**WELWYN HATFIELD COUNCIL – DEVELOPMENT CONTROL**  
**DELEGATED REPORT**

| <b>APPLICATION No:</b> | <b>S6/2007/1351/FP</b> |

The application seeks full planning permission to erect a 1 ½ storey detached garage to the north east site boundary of the property. The detached garage would be situated to the far end of the rear garden and would be incidental to the main dwelling.

FOL/001

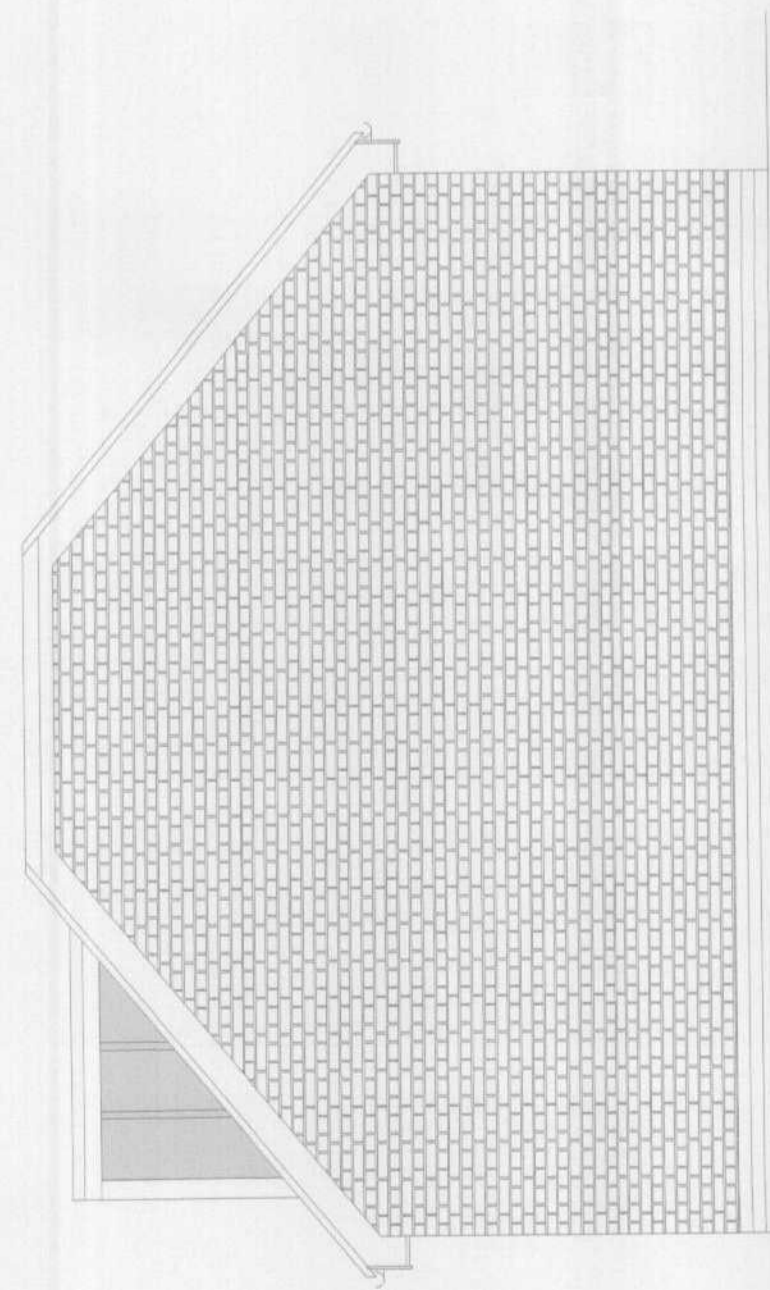
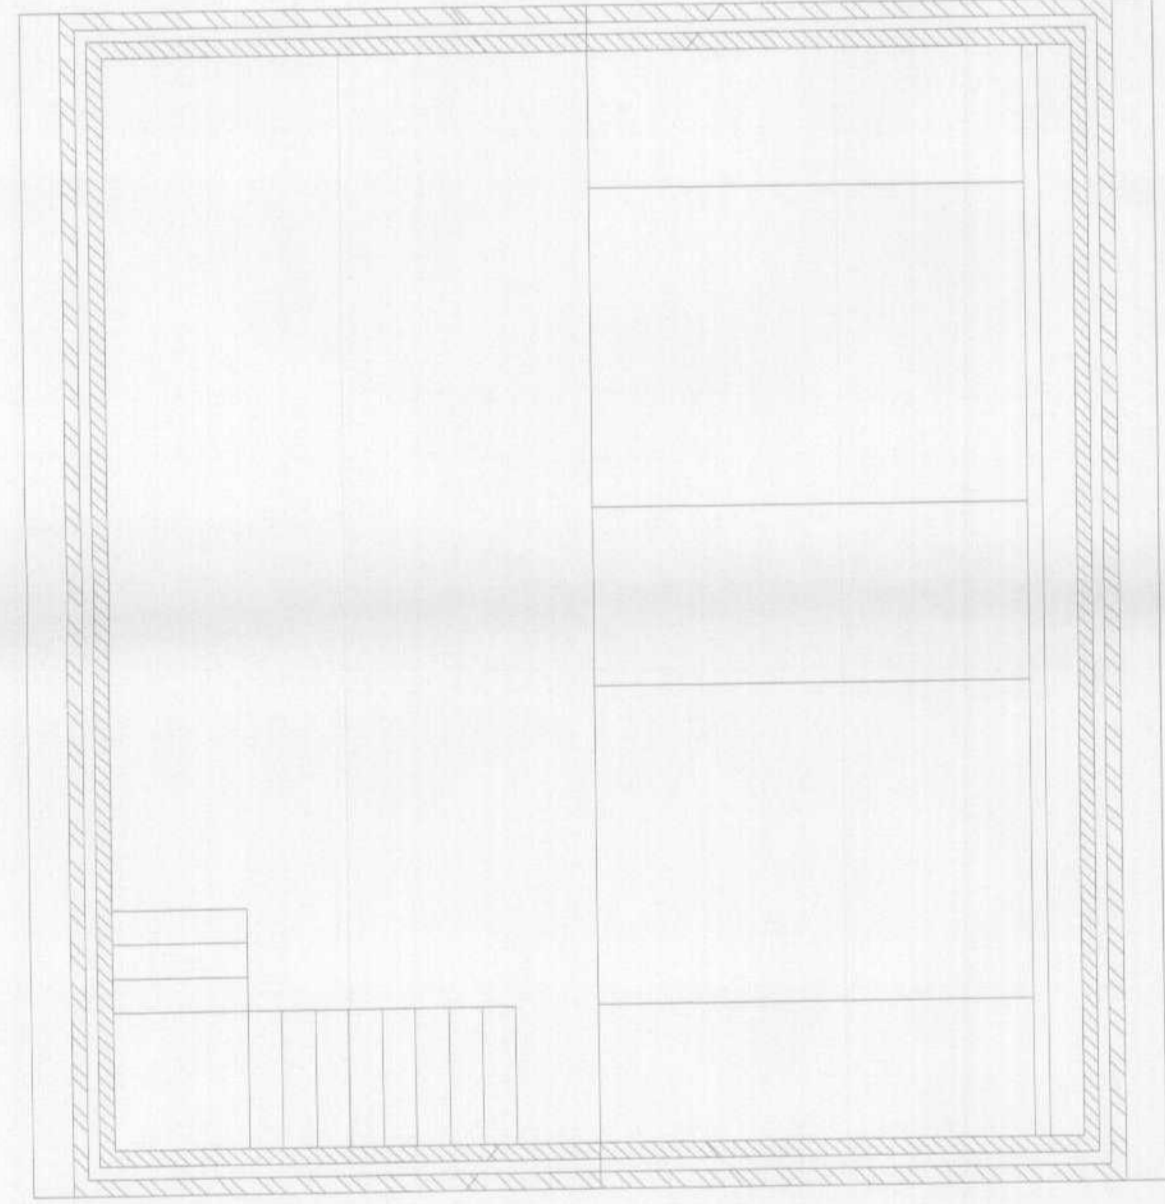
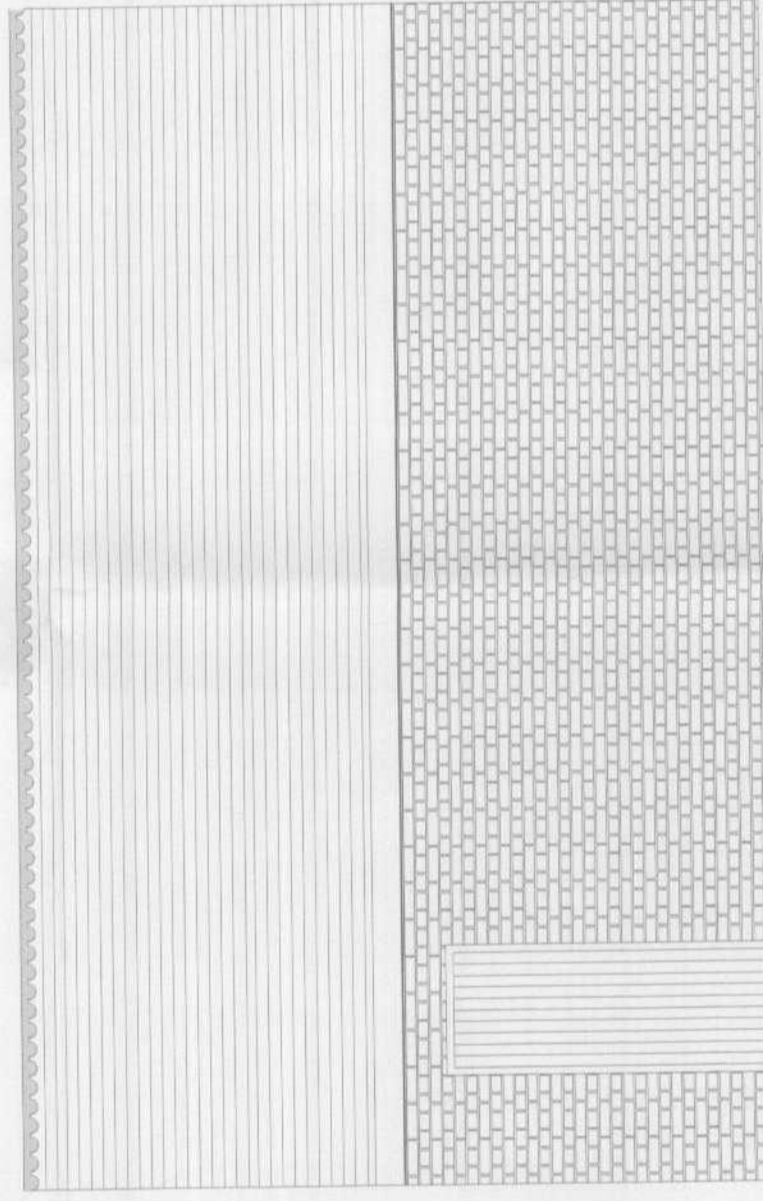
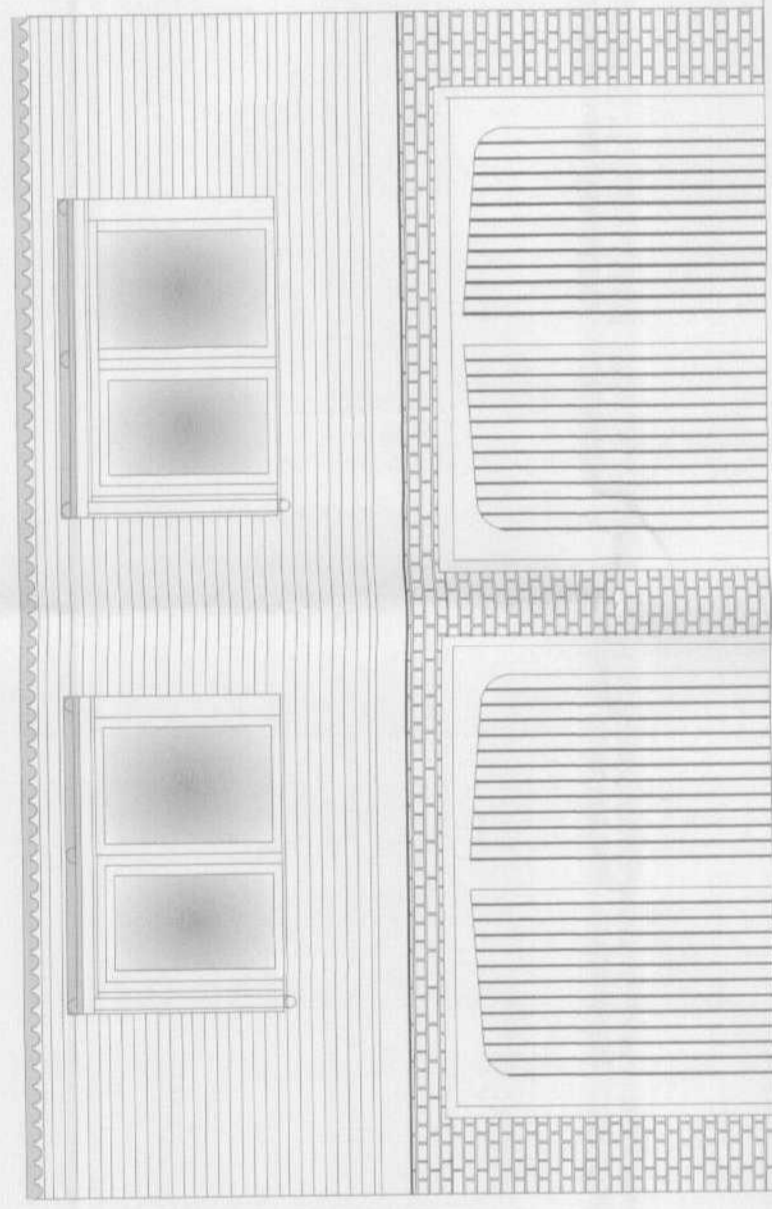
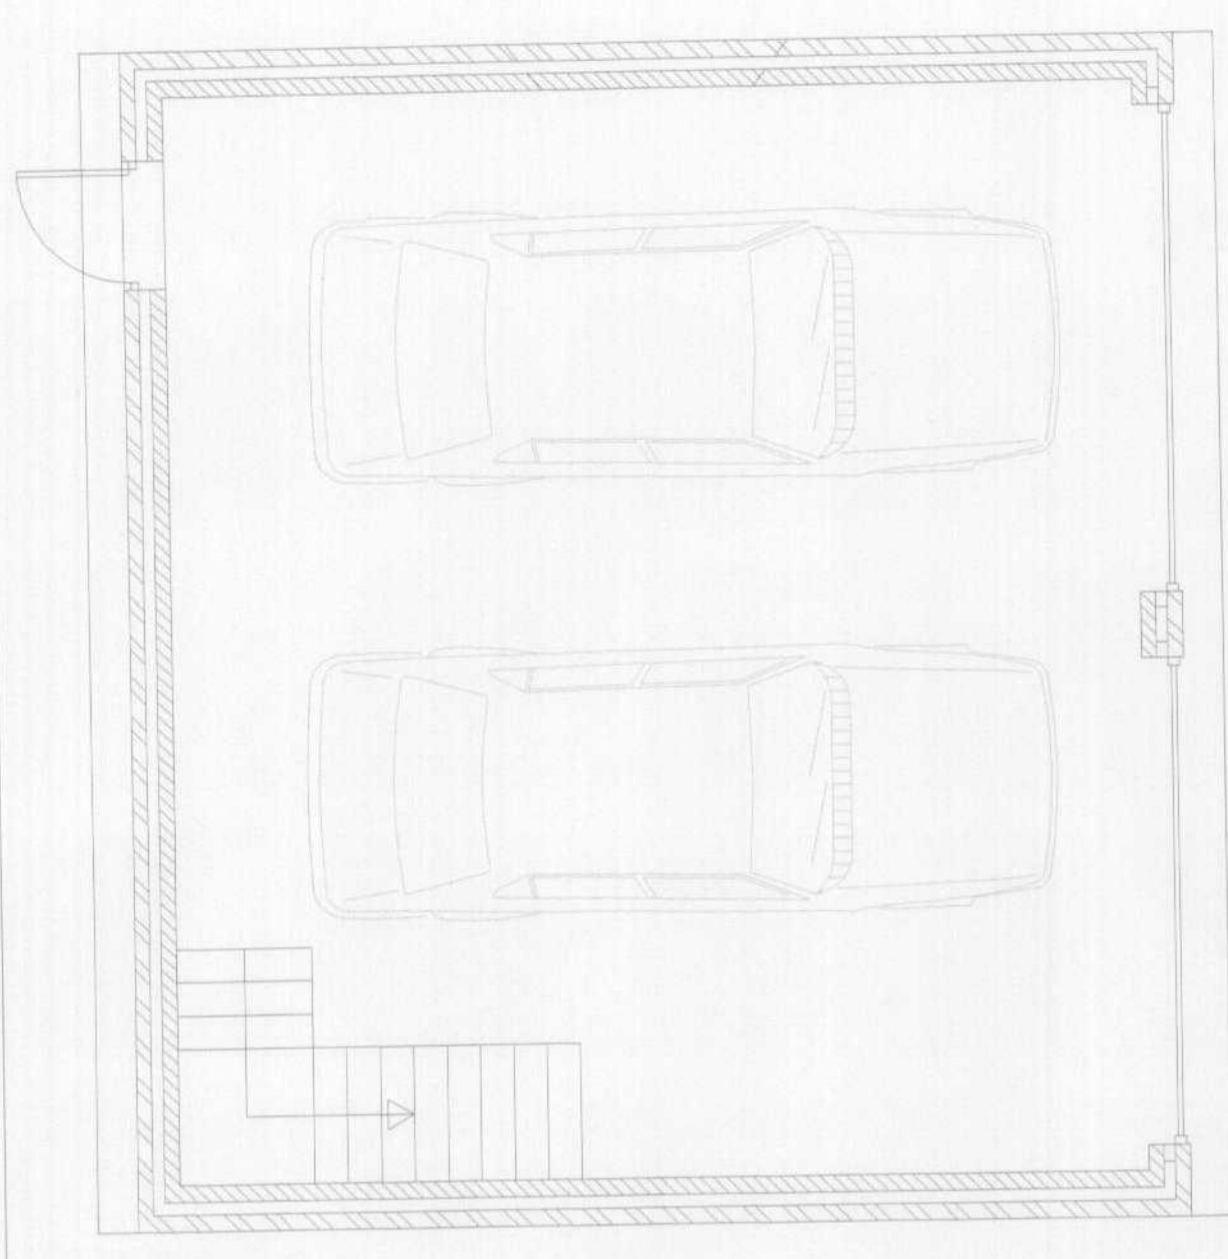
The garage design and bulk has been amended during the course of the application reducing the overall height to 5 metres (reduction of approx 1 metre) with a crown roof, two dormer windows to the front elevation with lead flank elevations. Furthermore, the design of the front facing elevation has been amended providing two separate garage doors to be finished in timber.

The bulk of the garage has been amended during the course of the application and further information submitted regarding its impact upon the character of the area. The height of the garage is 1 metre higher than what could be built under permitted development. The location of the garage is separated from the dwelling, however due to the built form in this area, it would not be possible to build a garage significantly closer than that proposed. Additionally, it is important to consider the impact in relation to the adjacent permitted garage (no. 4) and that beyond the immediate vicinity at Gable House/Coach house

With such a condition and with the amendments that have been sought, it is considered that the development now comprises appropriate development and is of a bulk, prominence etc that it now complies with policy RA3.

The proposed detached garage due to the amended design, is now considered to be in keeping with the character of the area and takes the opportunity of improving the character of the area. The materials proposed as well as brick work match and reflect both the main dwelling and changes to the front elevation are in keeping with the wider setting of the listed building and as such is considered complies with policies D1 and D2.
